**WELWYN HATFIELD BOROUGH COUNCIL  
EXECUTIVE DIRECTOR - PLANNING, PUBLIC PROTECTION AND GOVERNANCE**

**DELEGATED APPLICATION**

**Application No:** 6/2021/2600/HOUSE  
**Location:** 28 Thistle Drive Hatfield AL10 9FQ  
**Proposal:** Conversion of roof space to habitable use to include a front and rear dormer, 1 x skylight, and the erection of a single storey front, side and rear extension  
**Officer:** Ms Ashley Ransome

**Recommendation:** Refused

PROPOSED GROUND FLOOR PLAN
(scale 1:50)

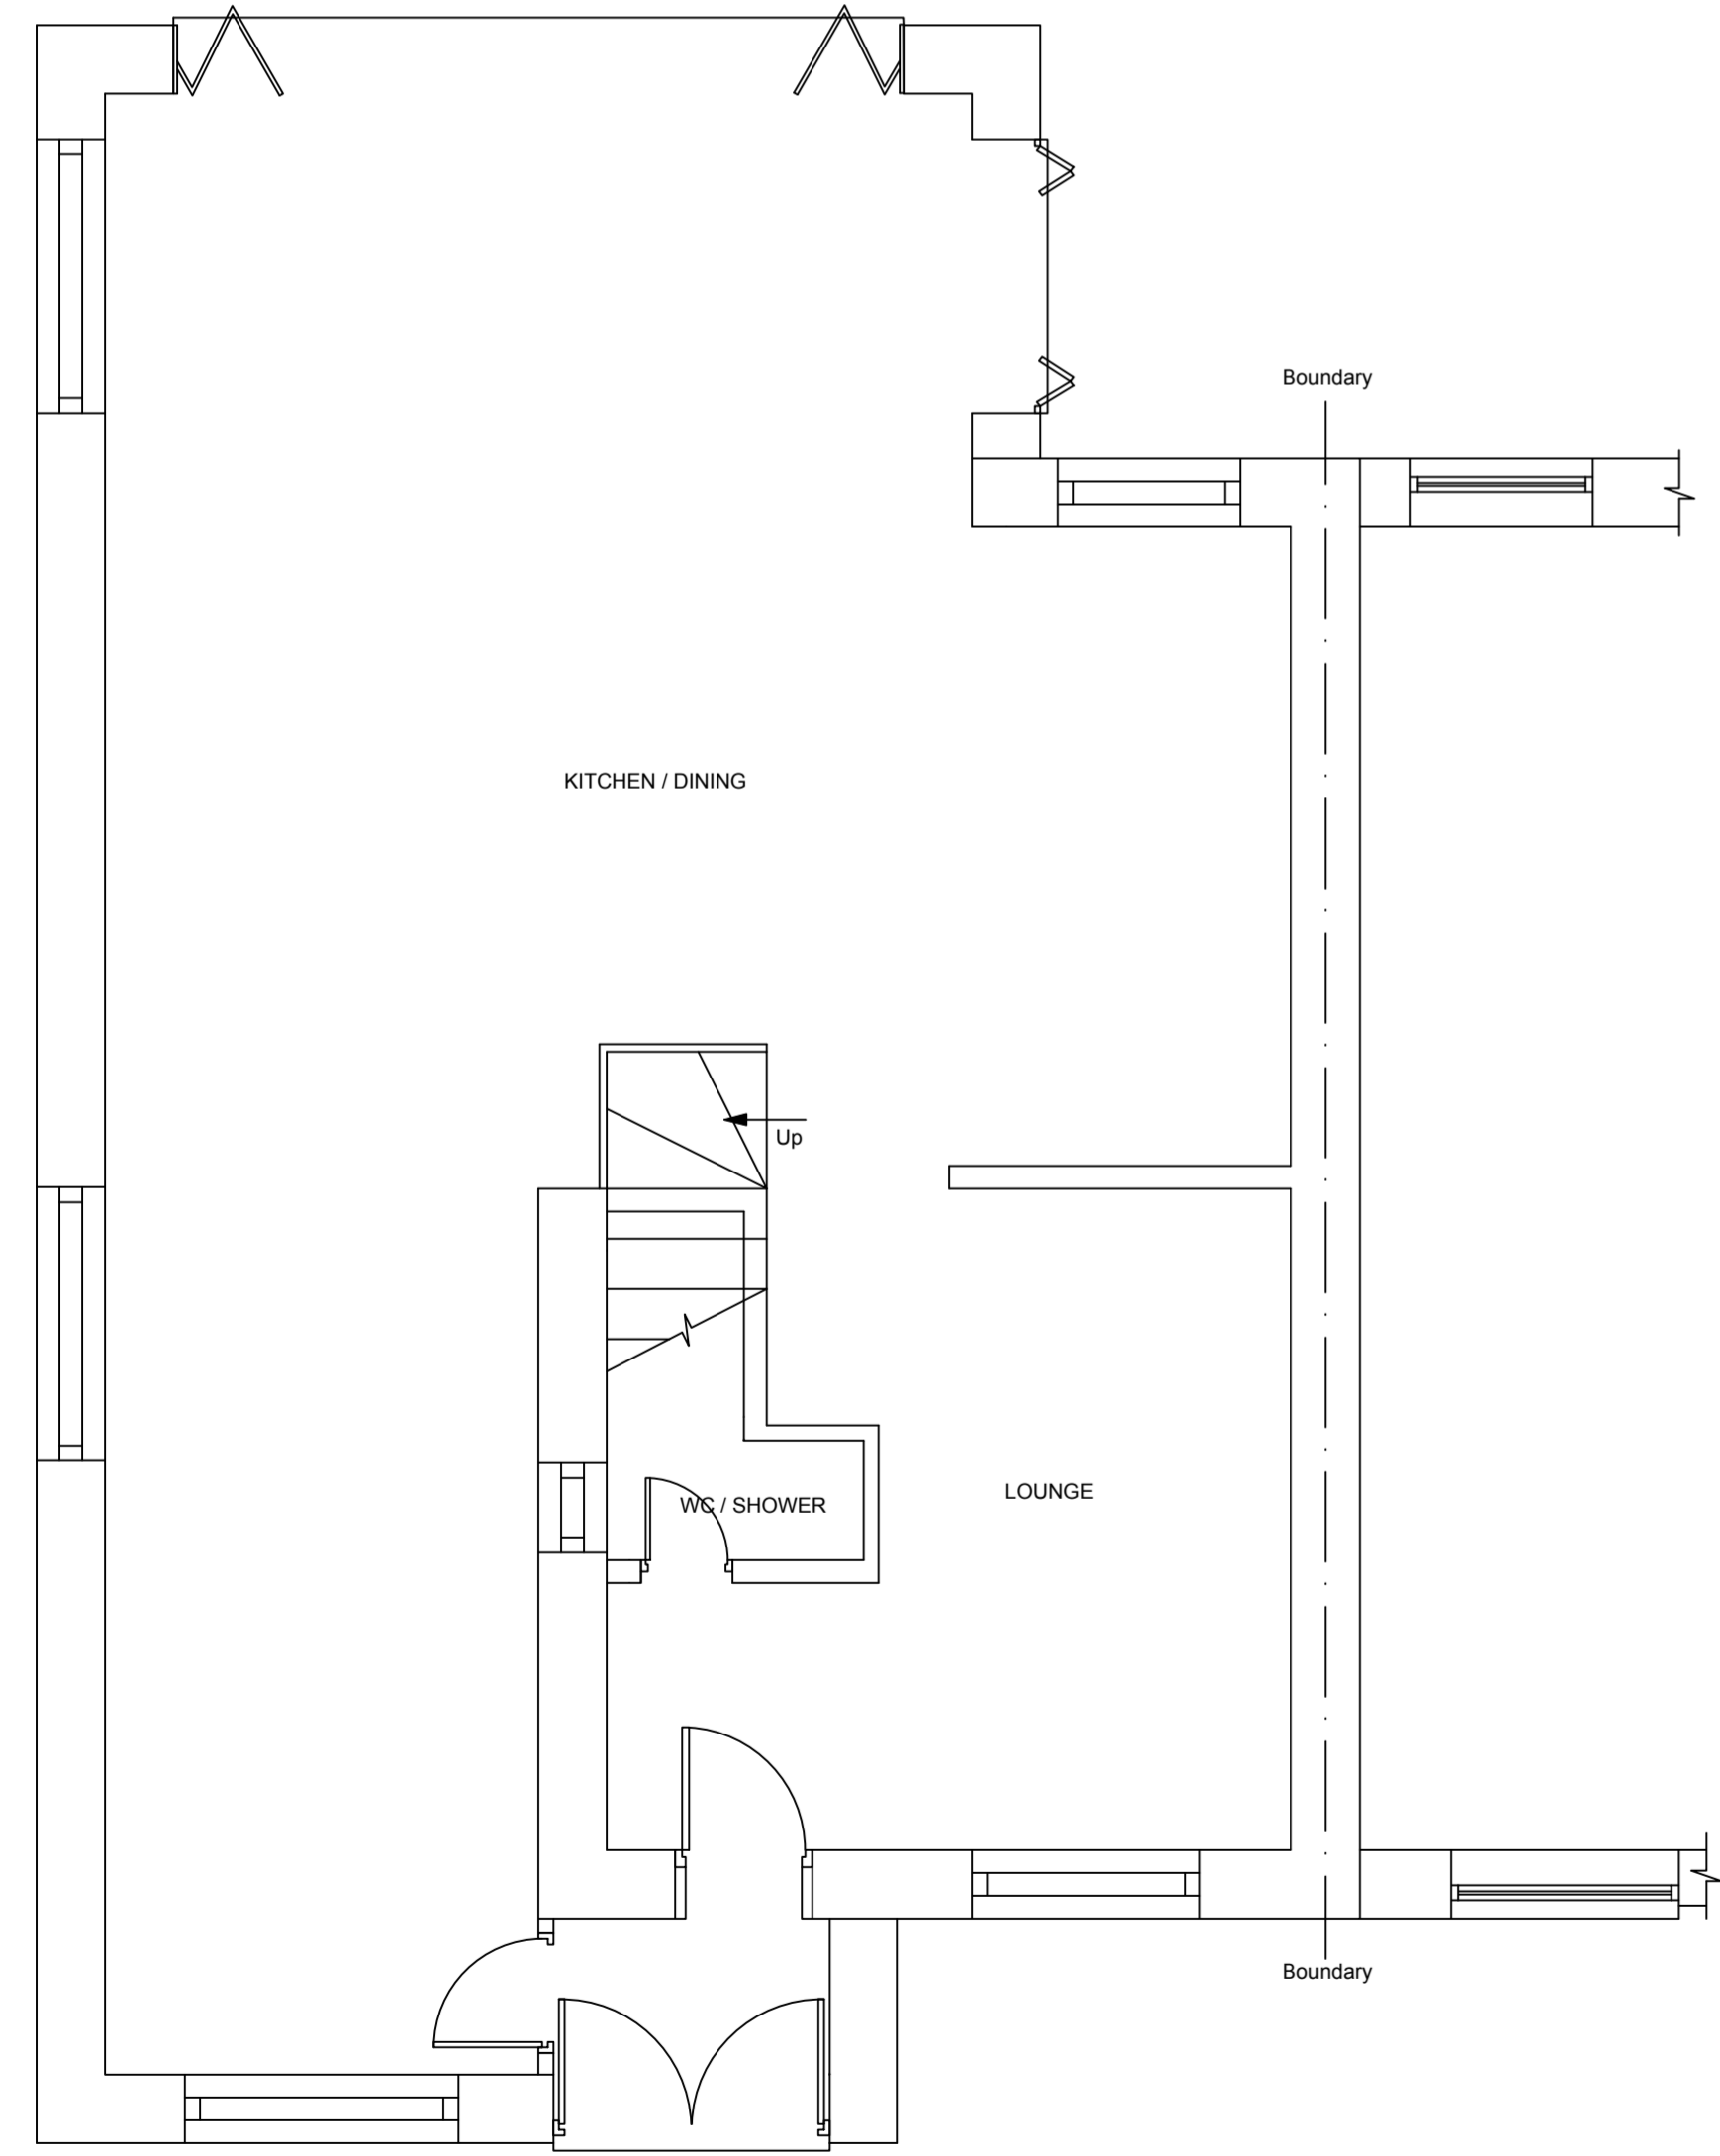
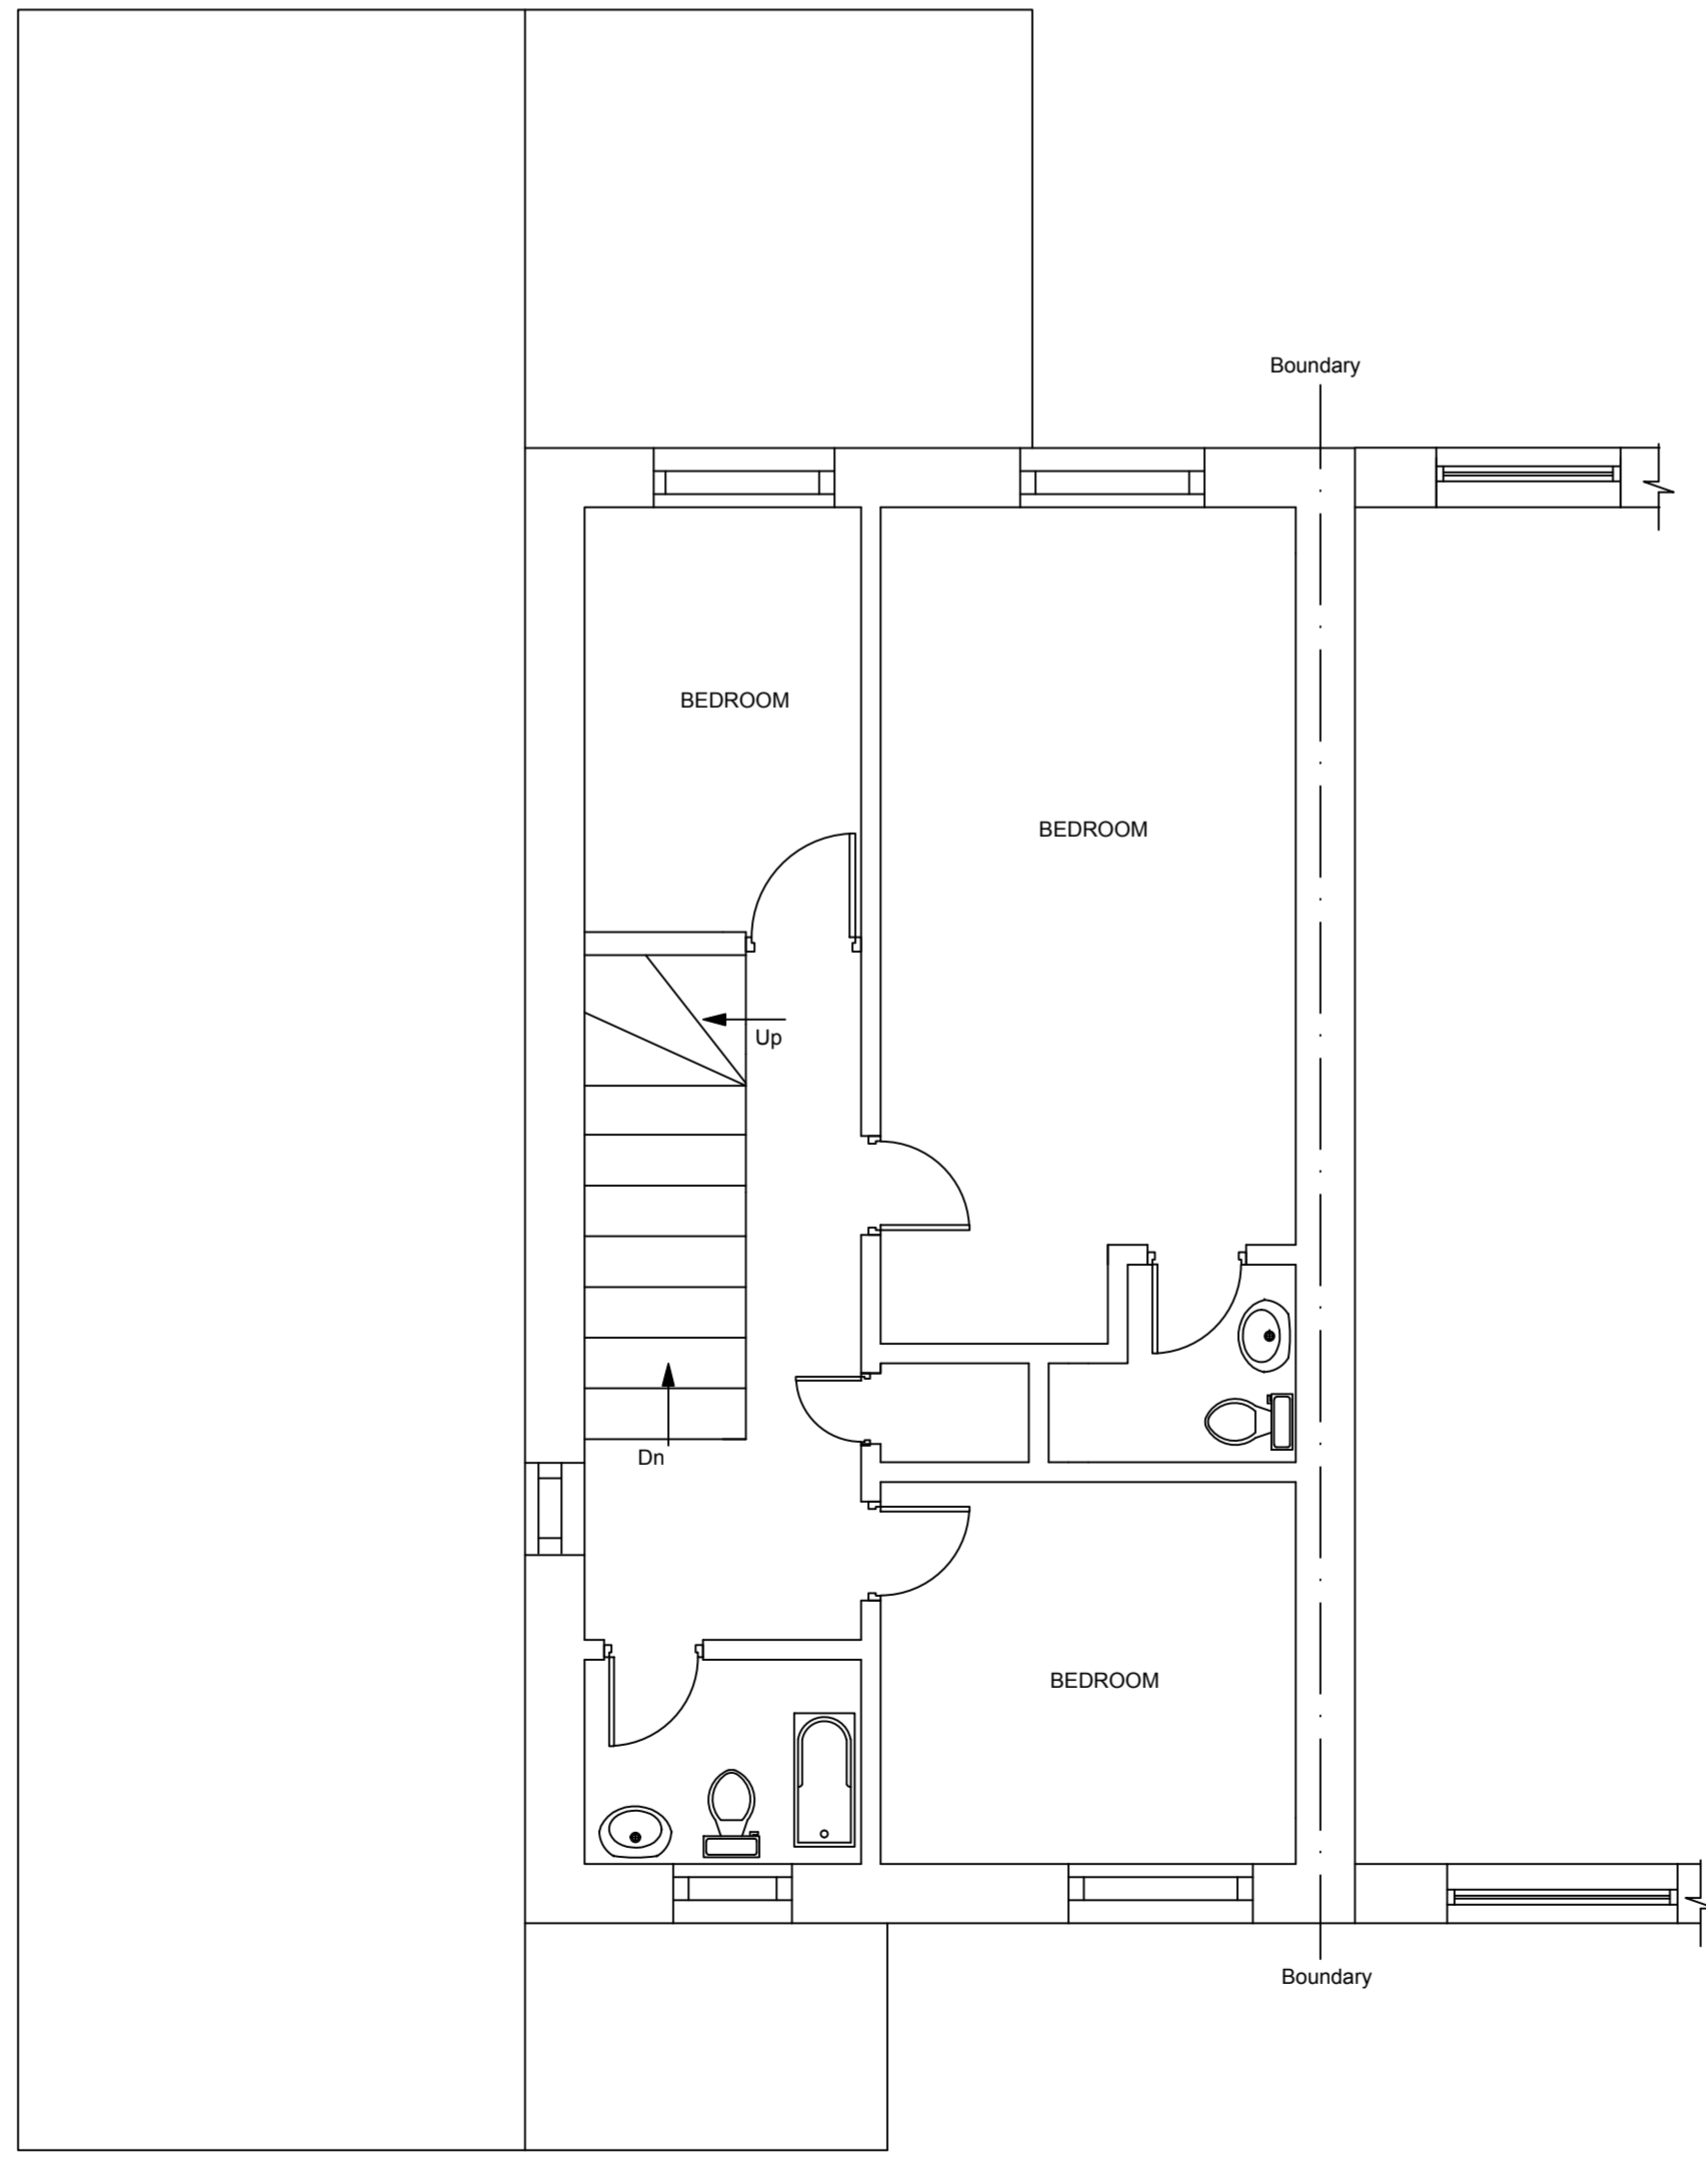
<p>The Council's Supplementary Design Guidance states at paragraph 5.2 that extensions should be designed to complement and reflect the design and character of the host dwelling and they should be subordinate in scale. Extensions must not reduce the amount of space around the dwelling to such an extent that the dwelling looks cramped on its site, and the spacing of buildings adjacent to and in the locality of the site should be reflected.</p> <p>It is considered that the proposed single storey front-side-rear wrap around extension would fail to represent a subservient addition to that of the existing dwelling. This is because it would create a significantly larger footprint than that of the existing dwelling, appearing over dominant and excessive.</p> <p>As a consequence of the above, it is considered that the proposed development would not reflect the character and appearance of the surrounding area and it would have a harmful impact upon the character of the dwelling. Accordingly, it is considered that the proposed development represents a poor standard of design and is therefore contrary to Policies D1 and D2 of the Welwyn Hatfield District Plan 2005, Policy SP9 of the Welwyn Hatfield Draft Local Plan 2016, the Welwyn Hatfield Supplementary Design Guidance 2005 and the National Planning Policy Framework 2021.</p>

<p><b>Impact on neighbours</b></p>	<p>The impact of the proposed development on the residential amenity of neighbouring dwellings is considered in terms of the impact on neighbouring properties access to day/sun/sky light, privacy, overbearing and overshadowing. Policy D1 of the District Plan seeks to provide a good standard of design in all new development. The Council's SPD on design supplements Policy D1 outlining that residential applications for extensions and alterations should not cause loss of light or be unduly dominant from adjoining properties, as a result of either the depth of the projection, the height or proximity of the extension.</p> <p>No neighbour representations have been received.</p> <p>Due to the distance, it is considered that occupants of neighbouring properties to the east and south of the application site would not be negatively impacted as a result of the proposed development. There are no immediate neighbouring dwellings to the front of the site.</p> <p>With respect to the neighbouring dwelling adjoining the application site at No.26, whilst a single storey rear extension would be visible, it is not considered to pose significant impacts to the amenity of the neighbouring occupants at No.26. This is because it is of single storey level and sited off of the boundary.</p> <p>With the above, it is therefore considered that the size, scale, siting and design of the proposed development would have minimal impact on the residential amenity of the surrounding neighbouring properties and is considered acceptable and is in accordance with Policy D1 of the Welwyn Hatfield District Plan, Policy SADM11 of the Welwyn Hatfield Draft Local Plan 2016, the Welwyn Hatfield Supplementary Design Guidance 2005 and the National Planning Policy Framework 2021.</p>
